CITY OF ALBUQUERQUE

April 1, 2022

**Re: Champion Xpress Car Wash
9640 Universe Blvd NW
Traffic Circulation Layout
Engineer's Stamp 03-25-2022 (B10-D003J)**

Design: RJM	Proj: 21.226
Draw: MCM	Dwg: 21-226.dwg
Check: RJM	Tab: C2.1-FP
Scale: 1" = 20'	
Date: 03.25.2022	
Sheet: FIRE 1 PLAN	
Sheet No.: C-2.1

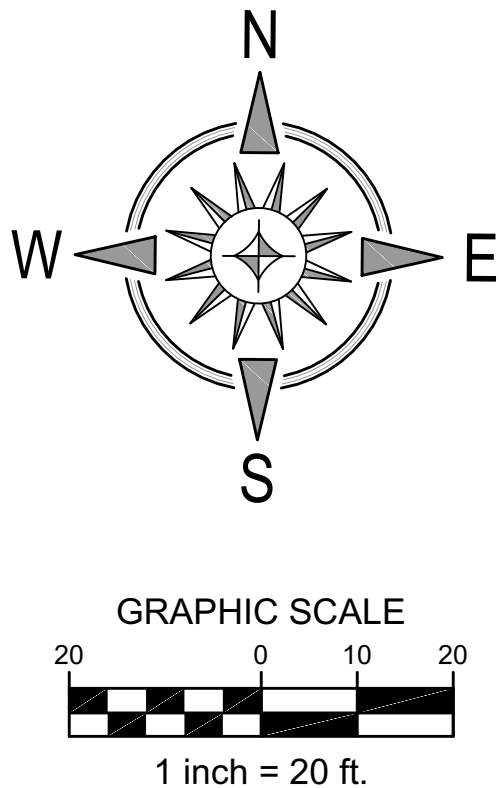
19. Fire Department: An approval Fire 1 plan needs to be provided.
20. All one-way drives shall have "One Way" and "Do Not Enter" signage (**provide on both sides of entrance/exit**) and pavement markings. Please show detail and location of posted signs and striping.
21. Pavement Markings: You will need to provide a detail for all proposed striping, stop bar, arrows, etc...

Tracts H-5A, H-6A, H-6B,
H-7A, H-8A and H-9A,
Ventana Square at Ventana Ranch
Being Comprised of
Tracts H-5 thru H-9
Ventana Square at Ventana Ranch
City of Albuquerque
Bernalillo County, New Mexico
July 2021

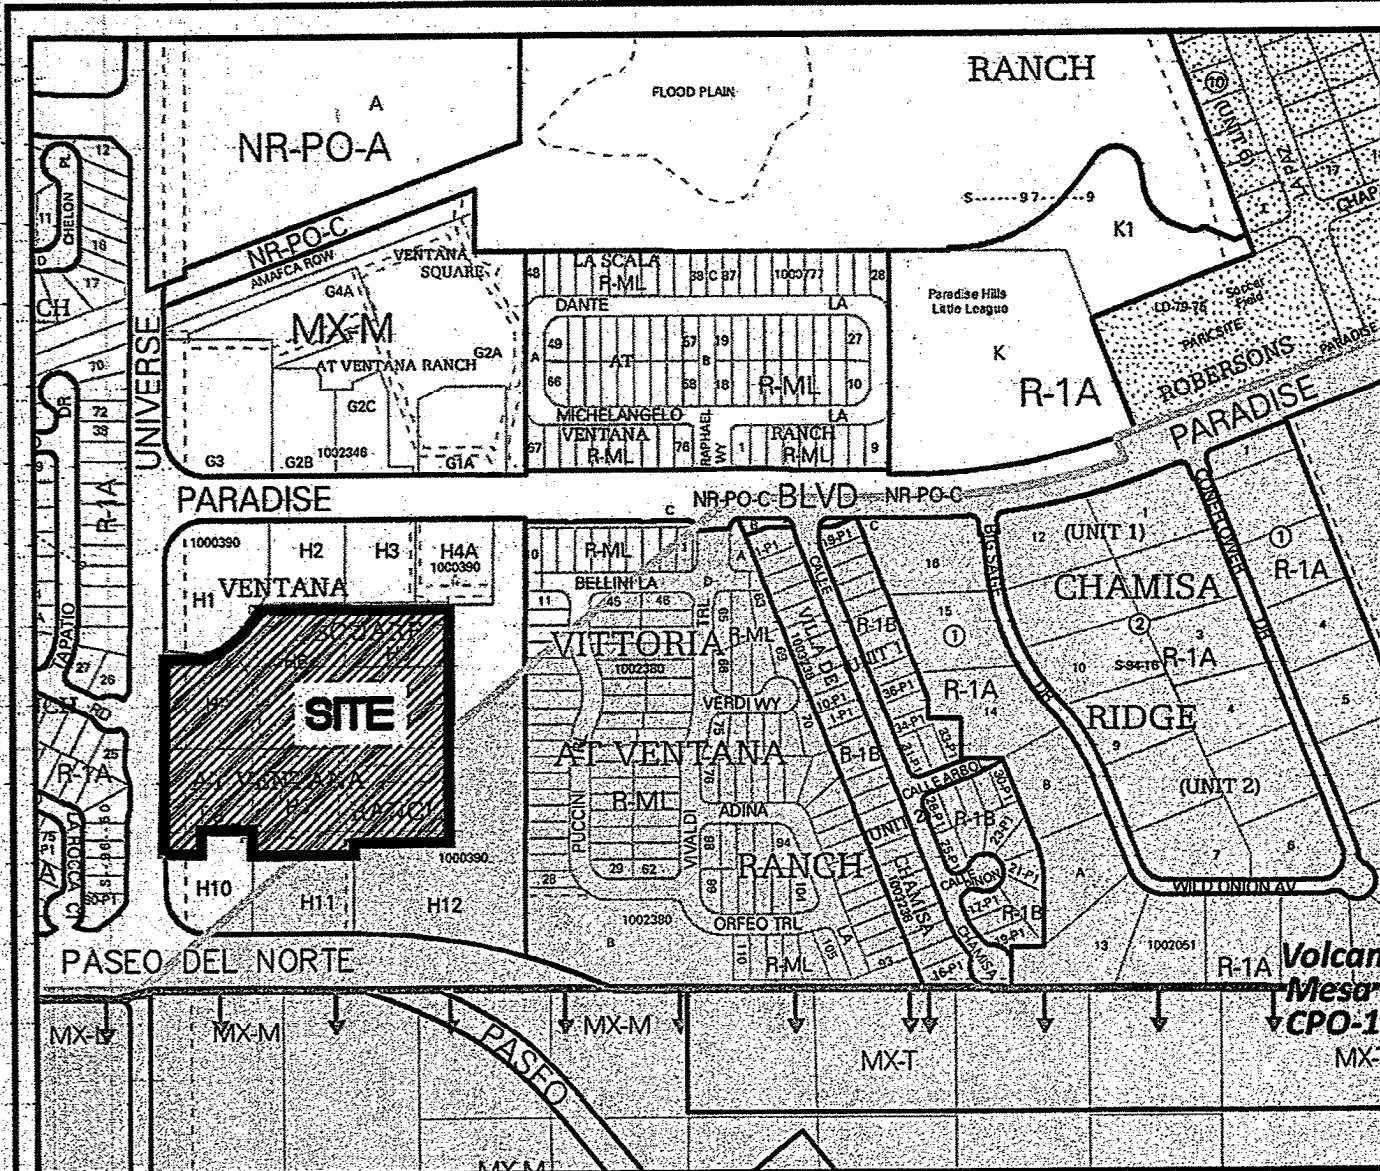
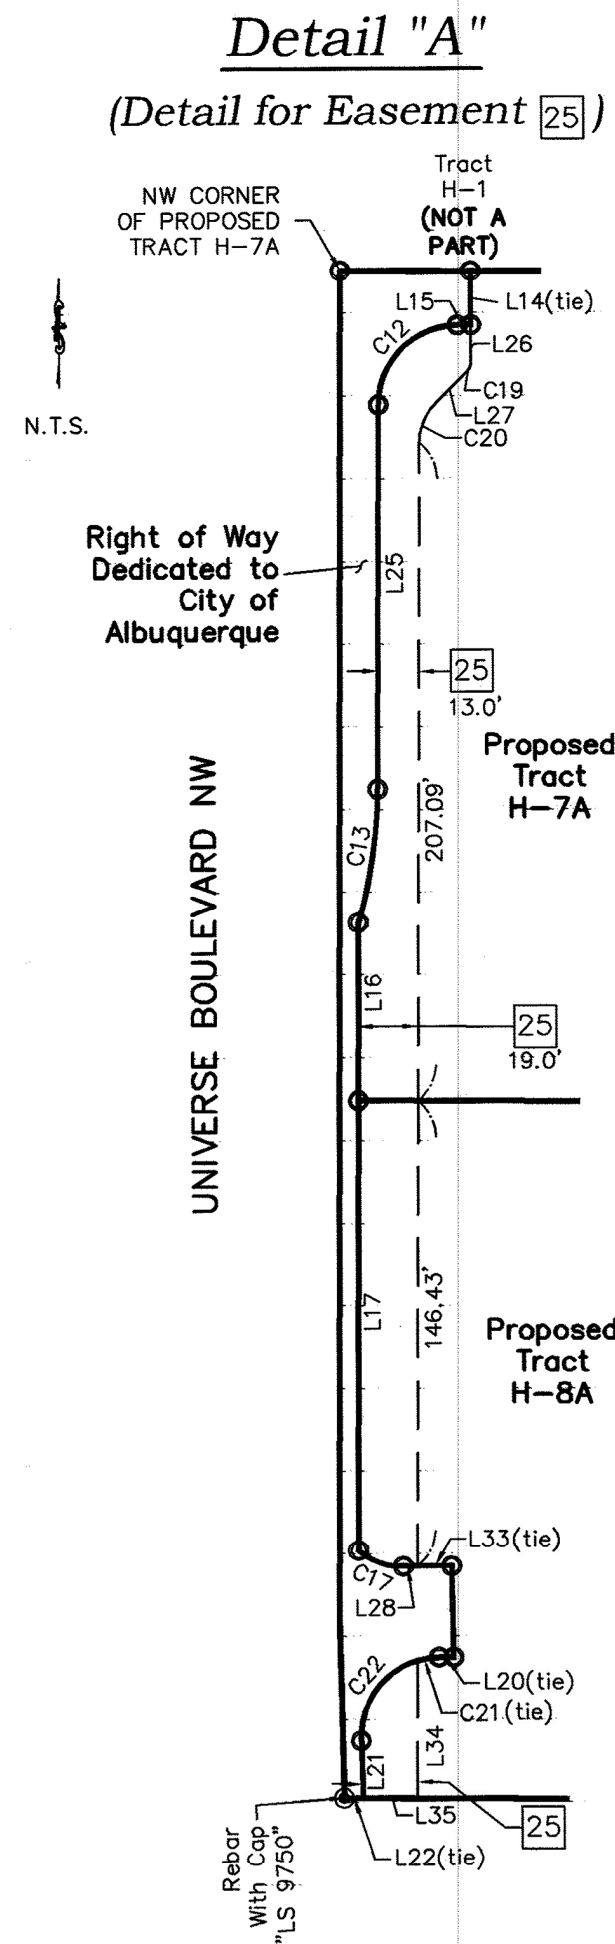
2. Please provide approved Plat demonstrating the 15 ft Private Access Easement shown on site plan and the modified property boundaries because AGIS demonstrates different boundaries/property lines from proposed Site Plan.

C-2.2

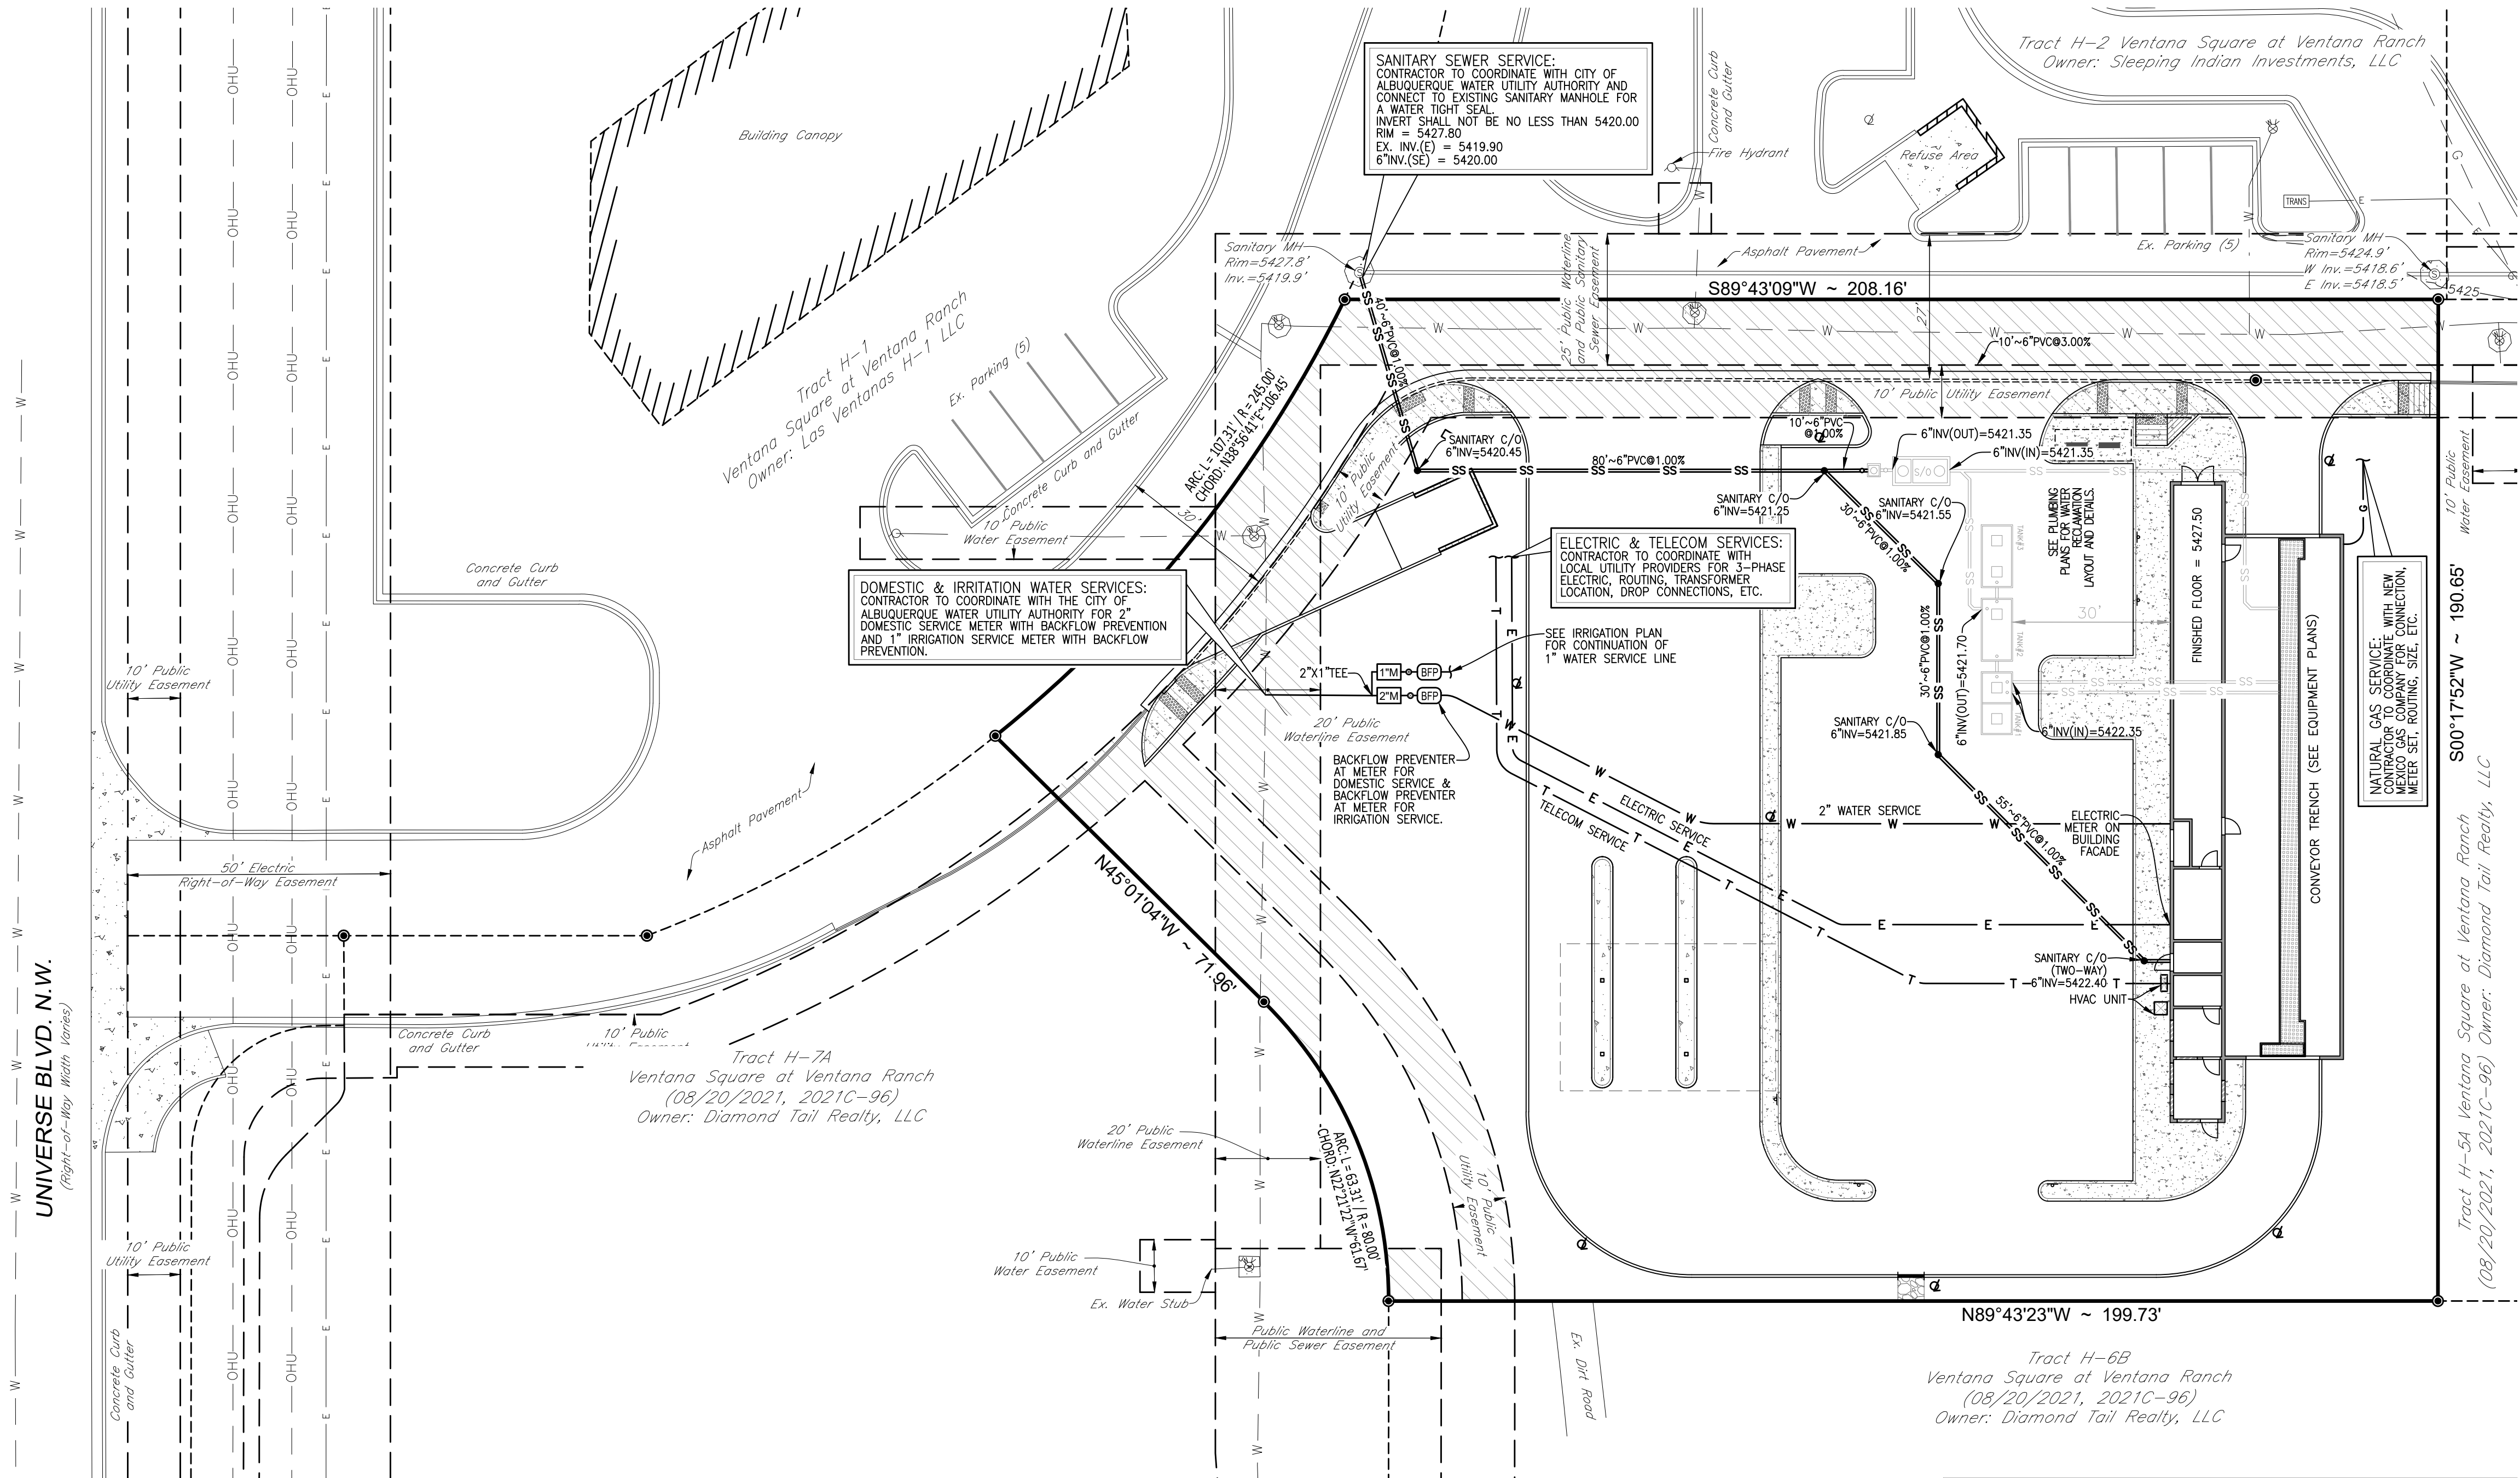
3. Please provide the pavement design for 15 ft and 28 ft Private Access Easement and will there be curbing along these segment? Status of valley gutter at junction of these two Access Easement?

4. **15 ft Private Access Easement (running West-East):**
 - Provide sidewalk connection from property onto adjacent properties (West-East).
 - Proposed parking stalls will not be allowed to back out onto Main drive aisle)15ft Private Access Easement).

- Provide barricading at end of Easement. Unless there a continuous lane eastbound.
 - Proposed Curbing : Detail will be needed.
 - Provide driveway design to include valley gutter and ramp details.

- Eastside ramp (end of property): Provide a 6:1 tie in grade back to existing elevation to avoid any safety hazard. Provide the sidewalk width and detail.

- You have 3 lanes directly off this Easement for the ingress driveway/drivethru lane. Traffic flow concern might be an issue, please explain your strategy versus traffic congestion off the proposed throat depth of 3 lanes.

- The 14 ft driveway has proposed ramp on eastside but not ramp on westside putting ADA patron in a hazardous situation. Please address this safety concern. Continuity for sidewalk is in question across the frontage for adjacent properties.

- What is the total width of the Access/drive aisle adjoining the proposed 15 ft Access Easement?
- 5. Minimum concrete pavement is 6 inches. Please provide a concrete pavement calculations to justify on 5 inches.

- 12. List radii for all curves shown; for passenger vehicles. Radius for delivery trucks, fire trucks, etc. is 25 ft. or larger. **Minimum internal radii's will need to be 15 'R's.**

- 13. Per the DPM, a 6 ft. wide ADA accessible pedestrian pathway is required from the public sidewalk to the building entrances. Please clearly show this pathway and provide details. **You have 6ft pathway that goes no where near the entrance. Explain?**

- 14. Per DPM, a 6 ft. wide ADA accessible pedestrian pathway is required from the ADA parking stall access aisles to the building entrances. Please clearly show this pathway and provide details. **You will need a ramp to connect access aisle to pathway to restroom entrance.**

- 17. Parking bumpers: Detail will be needed.
- 18. Refuse vehicle maneuvering shall be contained on-site. The refuse vehicle shall not back into the 15 ft Private Access Easement and 28 ft Private Access Easement. This is a

traffic conflict and will not be allowed. The proposed pathway will interfere where stop condition on the 28 ft Private Access Easement.

MONOLITHIC CONCRETE BARRIER CURB  
NOT TO SCALE

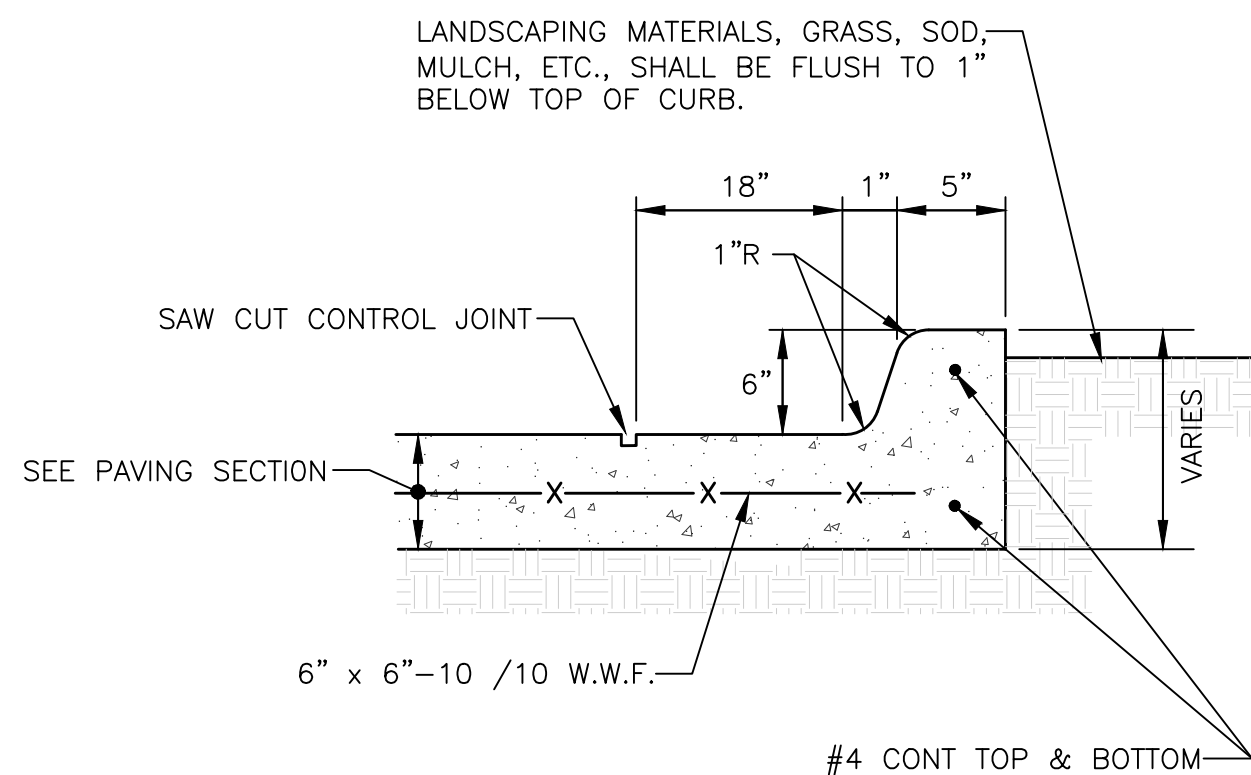
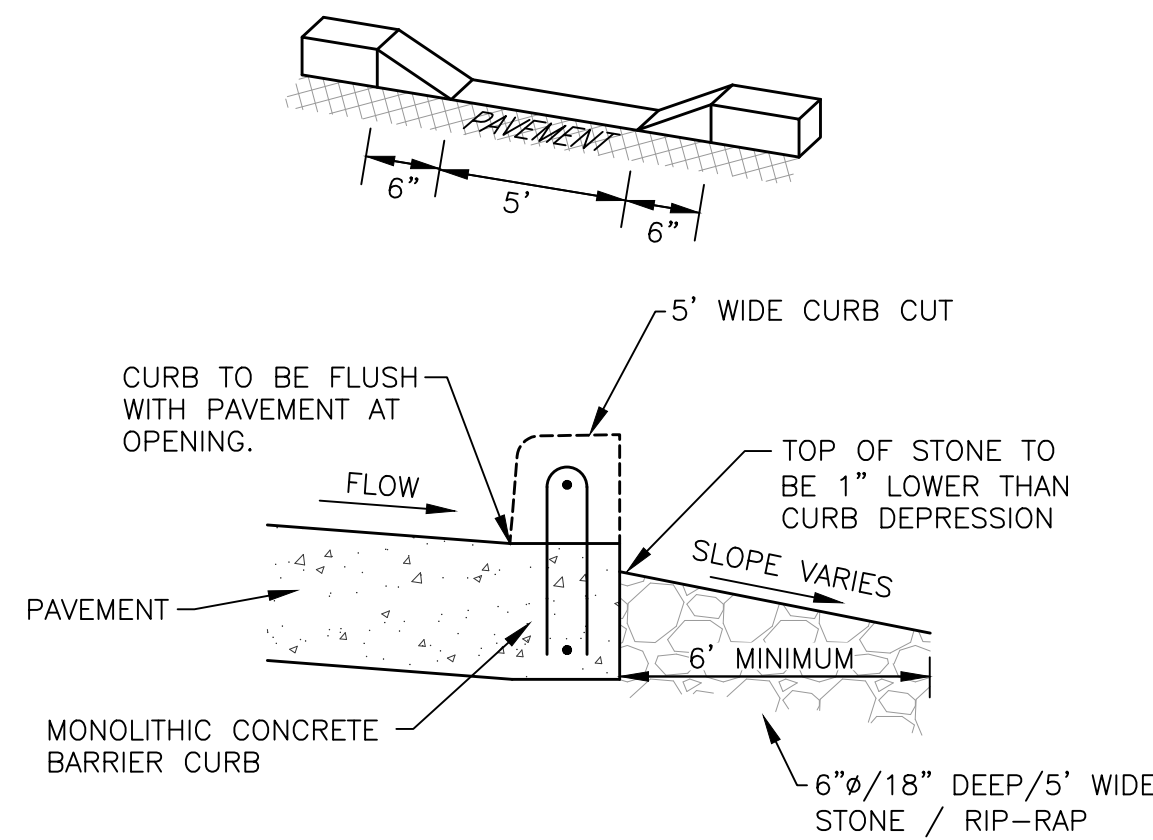
- 16. Curbing should be installed to delineate landscape, parking, and pedestrian ways and identify points of access. Please call out detail and location of barrier curb.

ADA ACCESSIBLE RAMP DETAILS  
NOT TO SCALE

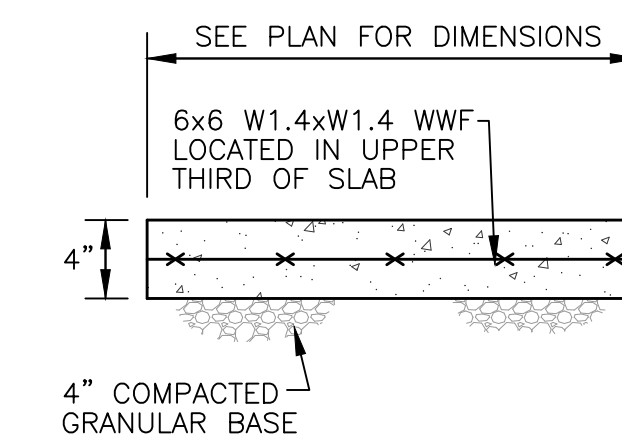
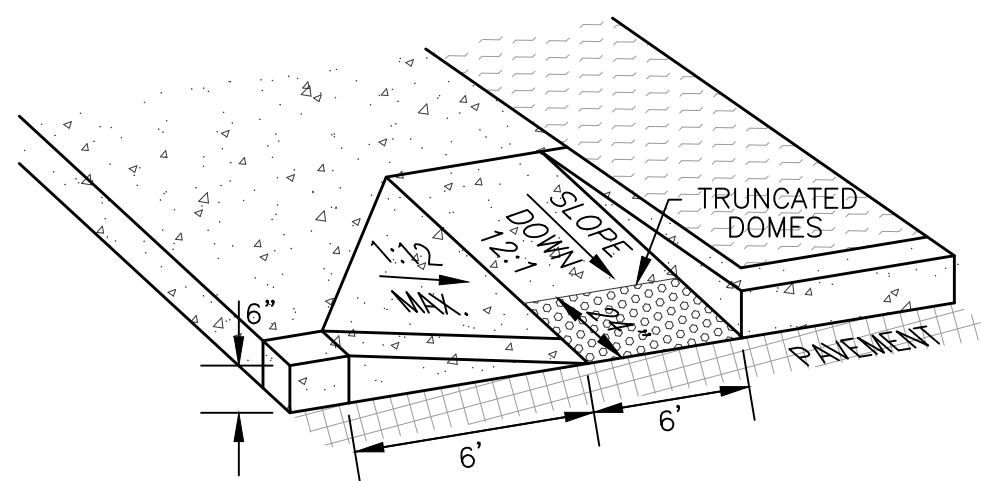
- 7. ADA curb ramps must be updated to current standards and have truncated domes installed. **Provide details for each type of ramp design.**
- 8. All bicycle racks shall be designed according to the following guidelines:
